CITY OF ALBUQUERQUE
PLANNING DEPARTMENT
October 30, 2013
DRB Comments

PROJECT # 1009876

APPLICATION # 13-70722

RE: Lot 3A1, North Hills Shopping Center

**SITE PLAN**  
FOR  
**LOTS 1-A, 2A-1, 2B-1 AND 3-A-1**  
NORTH HILLS SHOPPING CENTER  
CITY OF ALBUQUERQUE  
BERNALILLO COUNTY, NEW MEXICO  
SEPTEMBER, 2013

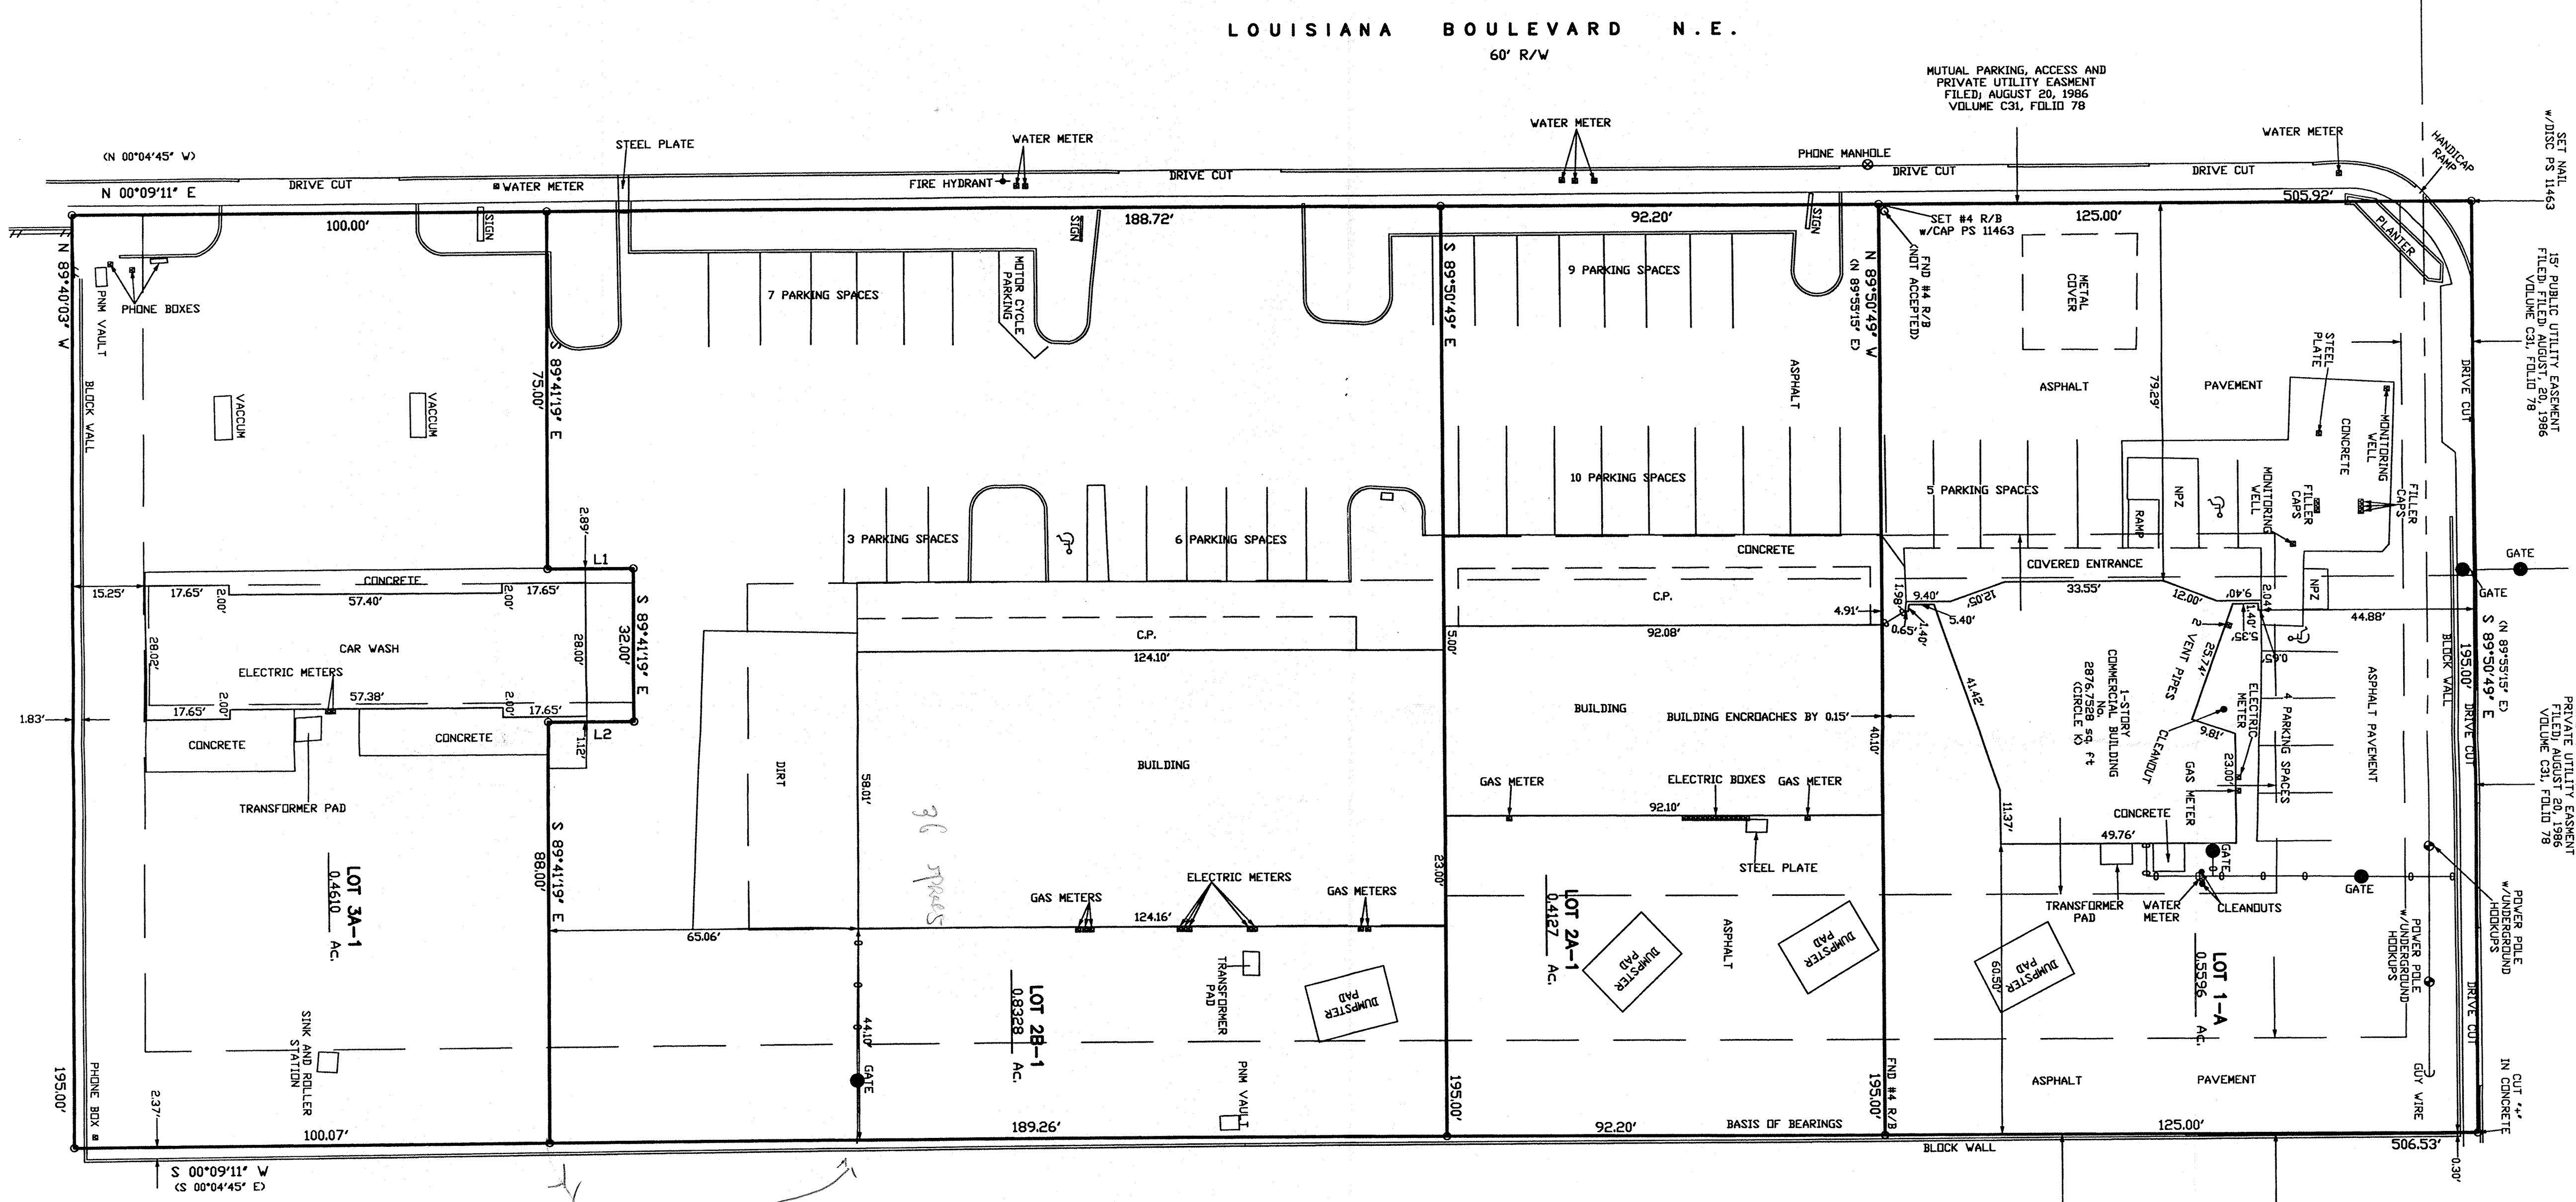
Parking calculations will be needed to demonstrate compliance with the Zoning Code, or a Parking Variance will be required.
